114 Harris Ave. - Permit 2016-02914

I have done the initial zoning review for the sunroom that was built "on the existing porch". At this point I cannot approve the permit for zoning.

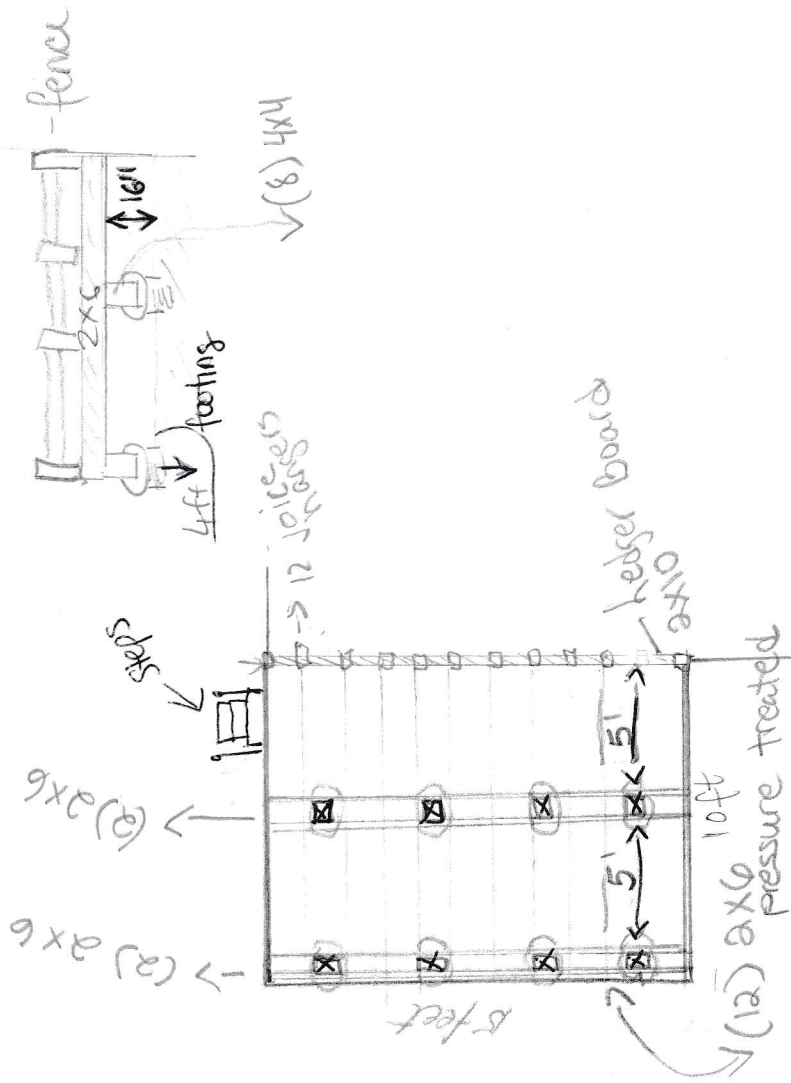
The property is in the R-3 zone. The side yard setback for a one story addition is 8 feet. The plot plan shows the setback to the house as 18 feet and the deck coming 15 feet off the side of the house. That leaves an 6' side setback which does not meet zoning. There is no permit on file for a 12' x 15' deck.

The property needs to be brought into compliance. You have two options. You can provide a plan drawn by a surveyor that shows that the existing sunroom meets the eight foot side setback, or two, you need to remove the part of the sunroom that does not meet the eight foot side setback. You have thirty days to let me know which option you choose to follow.
